From: Sarah Burrow
Sent: 06 January 2022 09:21
To: Planning.Responses
Cc: Amy Myer
Subject: RE: Planning Consultation on: CM/64/21/PL

Engineers Comments Regarding Surface Water Drainage

Application No: CM/64/21/PL
Registered: 10th November 2021
Site Address: Land adjacent to Church Farm Barn Horsemere Green Lane Clymping BN17 5QZ
Grid Reference: 500200 102450
Description of Works: Use of land for Class B8 (Storage) for caravan storage. This application may affect the setting of listed buildings & is in CIL Zone 3 (Zero Rated) as other development.

Drawing Title
Site Layout - AS PROPOSED

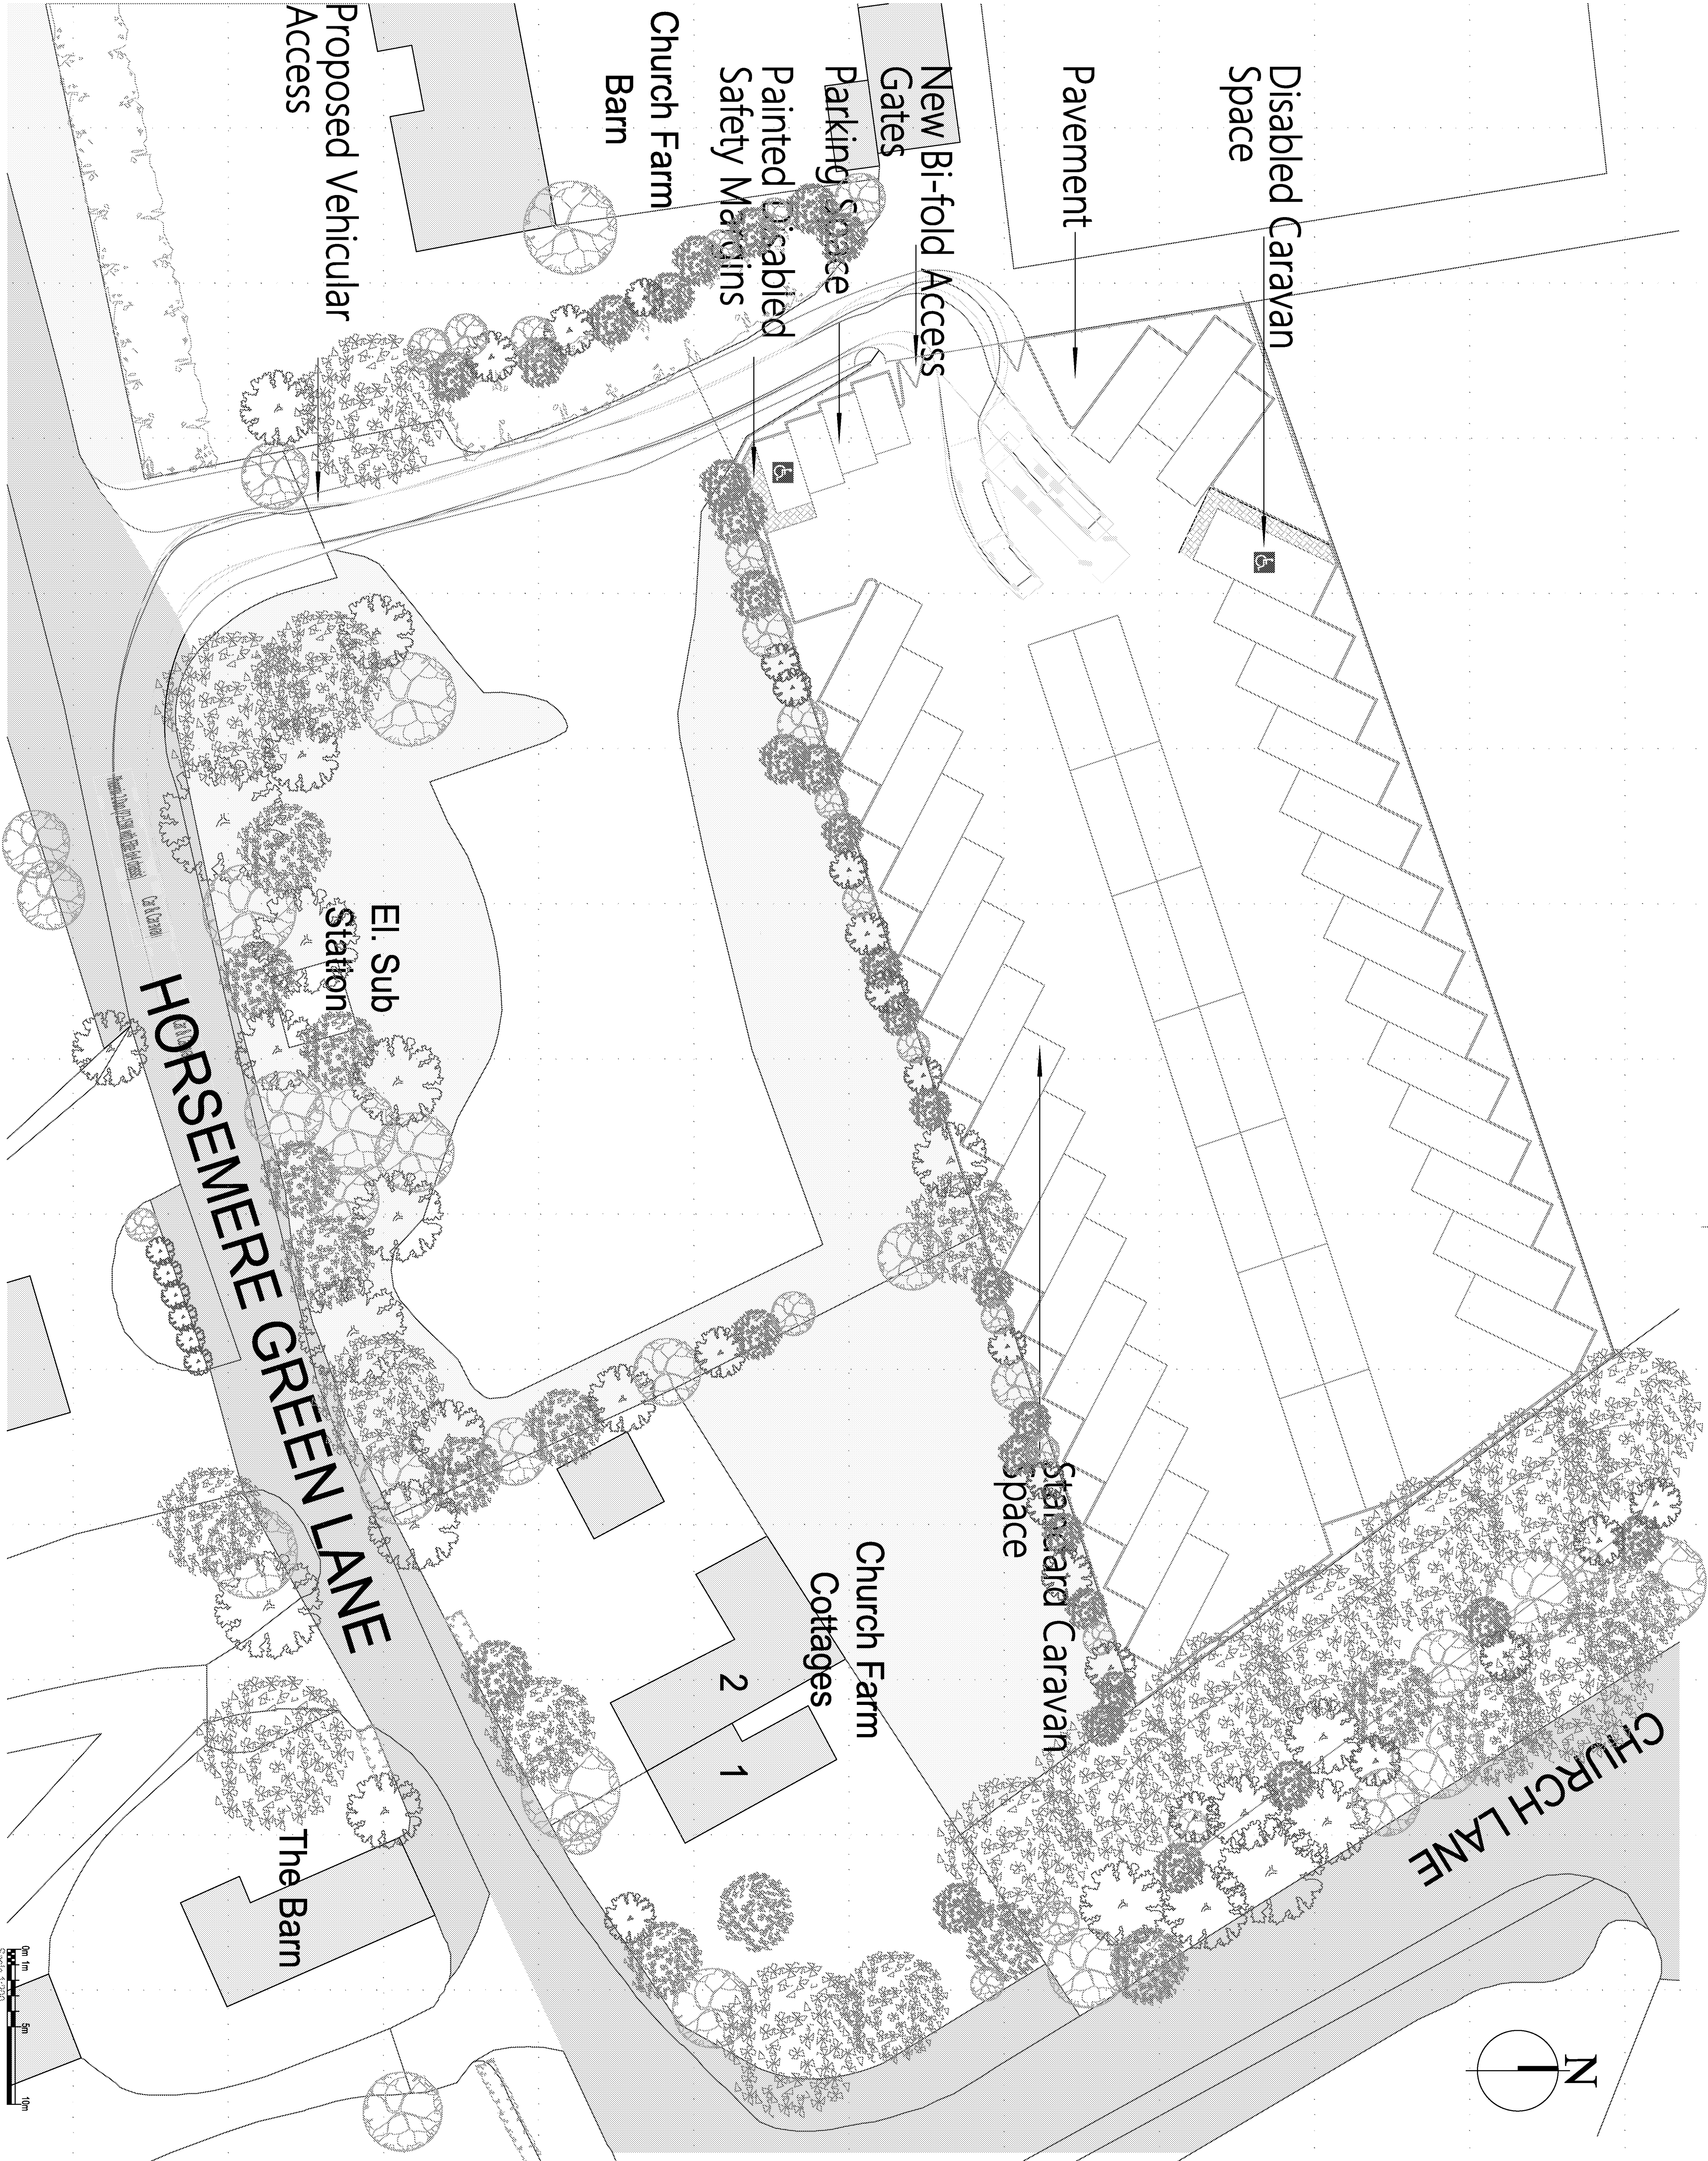
The addition of up to 46 caravans which will be rarely moved (as acknowledged by the applicant) represents a significant increase in impermeable area on the site. No detail has been given on what surface treatments, if any, are proposed. The application form states that a sustainable drainage system will be used but no site investigations or design have been submitted.

It is likely that groundwater will be found to be high in the area and there is a risk that infiltration may not be viable. If this is the case then there are no watercourses or surface water sewers bordering the site to which surface water could easily be discharged. If no sustainable surface water drainage solution can be found then we would oppose the proposed development, therefore I wish to lodge a **holding objection** at this time.

In order to overcome the objection I would require more detail regarding the proposed surface treatments, site specific winter groundwater levels and an indication of how the applicant intends to drain the site.

"Development shall not commence, other than works of site survey and investigation, until full details of the proposed surface water drainage scheme have been submitted to and approved in writing by the Local Planning Authority. The design should follow the hierarchy of preference for different types of surface water drainage disposal systems as set out in Approved Document H of the Building Regulations, and the recommendations of the SuDS Manual produced by CIRIA. Winter groundwater monitoring to establish highest annual ground water levels and winter Percolation testing to BRE 365, or similar approved, will be required to support the design of any Infiltration drainage. No building / No part of the extended building shall be occupied until the complete surface water drainage system serving the property has been implemented in accordance with the agreed details and the details so agreed shall be maintained in good working order in perpetuity."
